## Marge Schmuckal - 116 Walton St application

**From:** Marge Schmuckal  
**To:** joe@whipplecallender.com  
**Date:** 6/10/2013 2:18 PM  
**Subject:** 116 Walton St application  
**CC:** Brad Saucier

I am reviewing your application for 116 Walton Street. Please note that the last approved use was a two family. You are now changing from a two family to a single family handicap dwelling unit. There is a \$75 fee for a change of use. Please make arrangements with our front staff for payment.

1 Third Floor Plan
A1.4 SCALE: 1/4" = 1'-0"

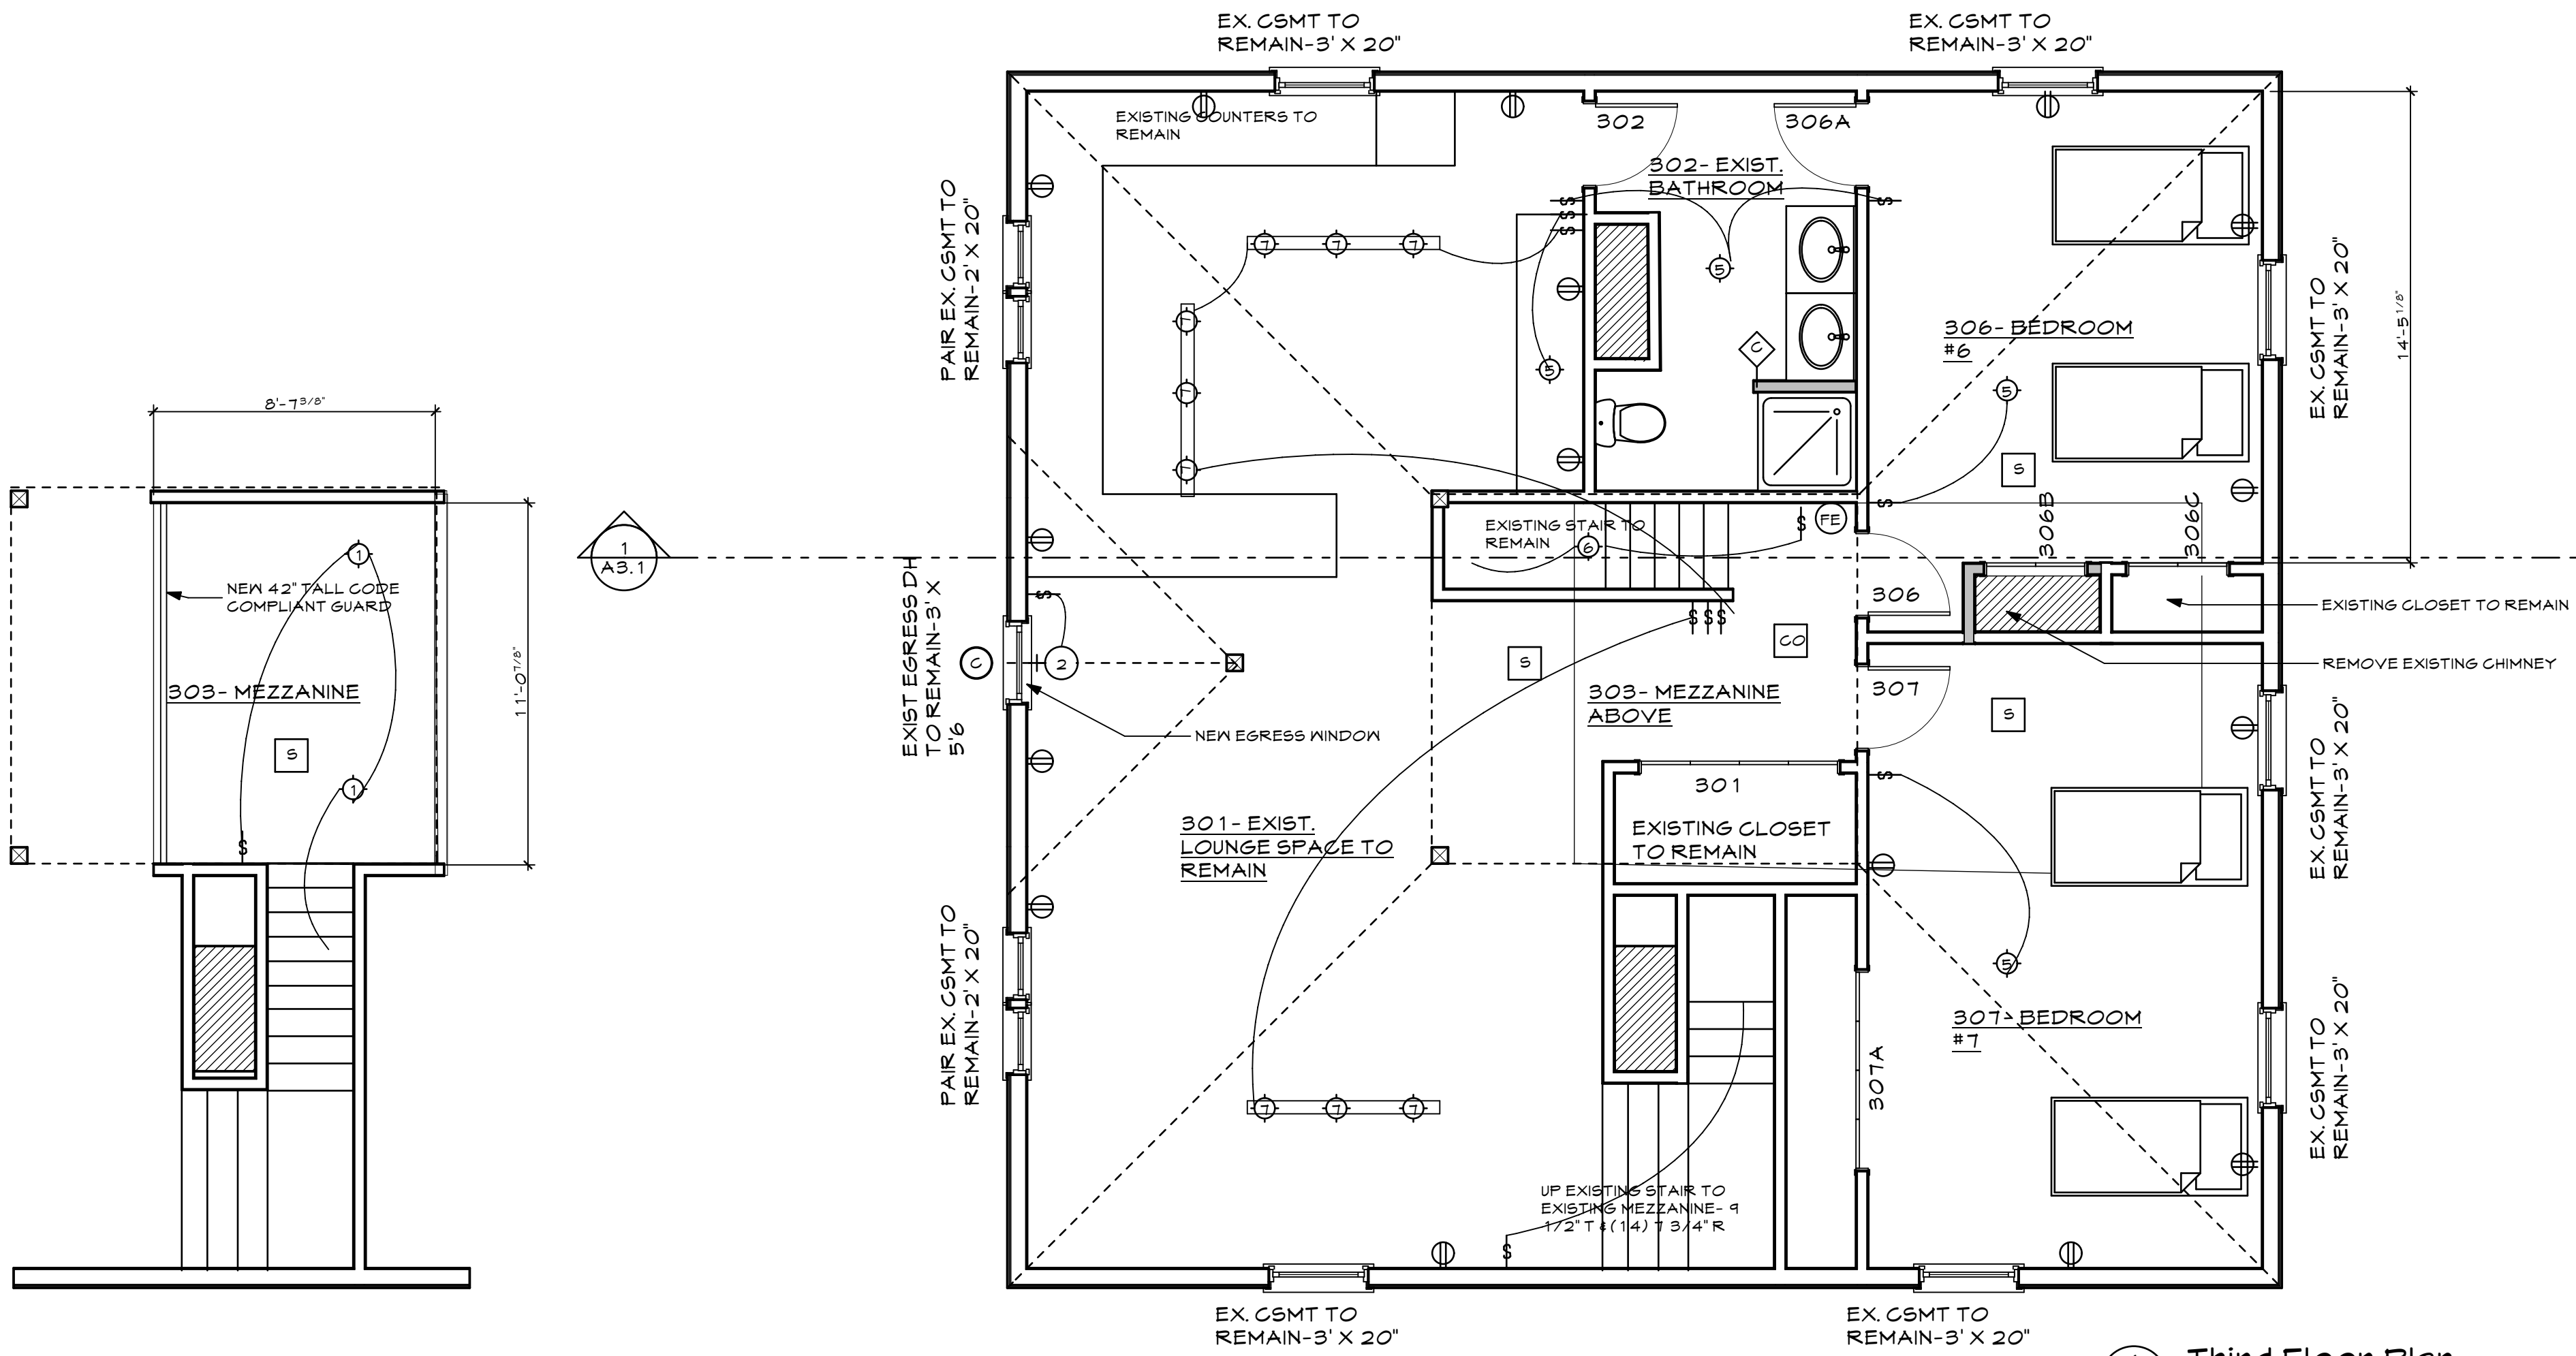
I am also counting 18 beds in the building. As you know, handicap family units do not allow more than 16 beds. Please revise your plans.

1 Detail 1 - site detail
 A6.2 SCALE: 1/2" = 1'-0"
 0 1 2 4

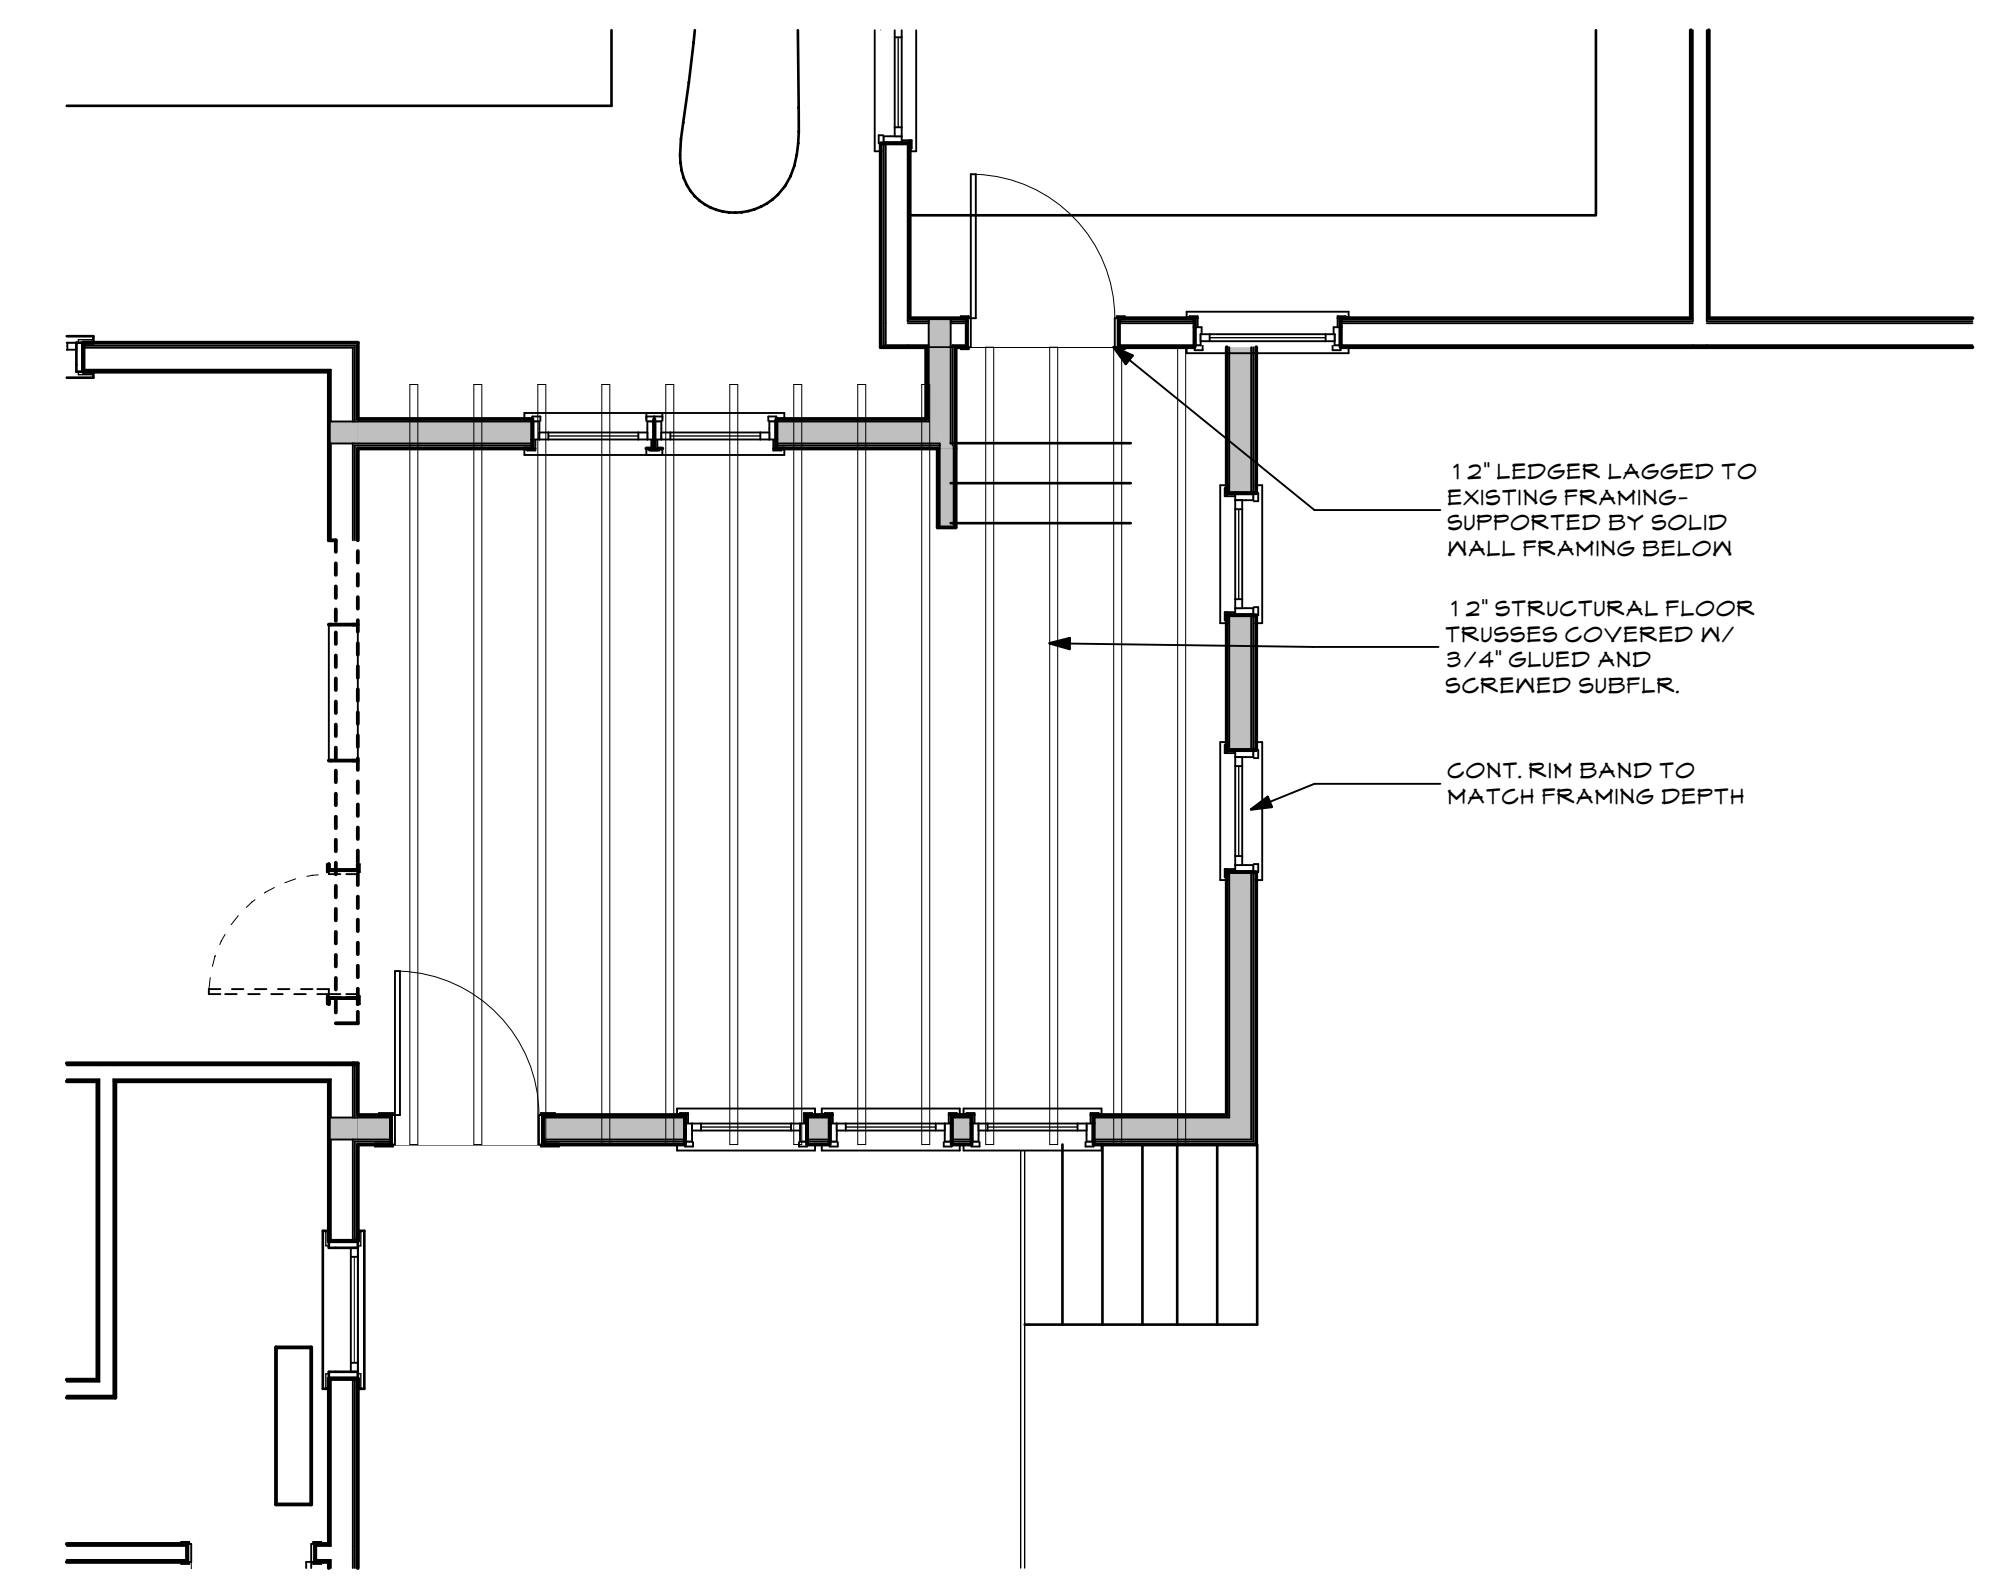
You will also need to revise your site plan to show the new bulkhead that is to be installed. Please remember that ALL projections from the structure must be shown on a site plan.
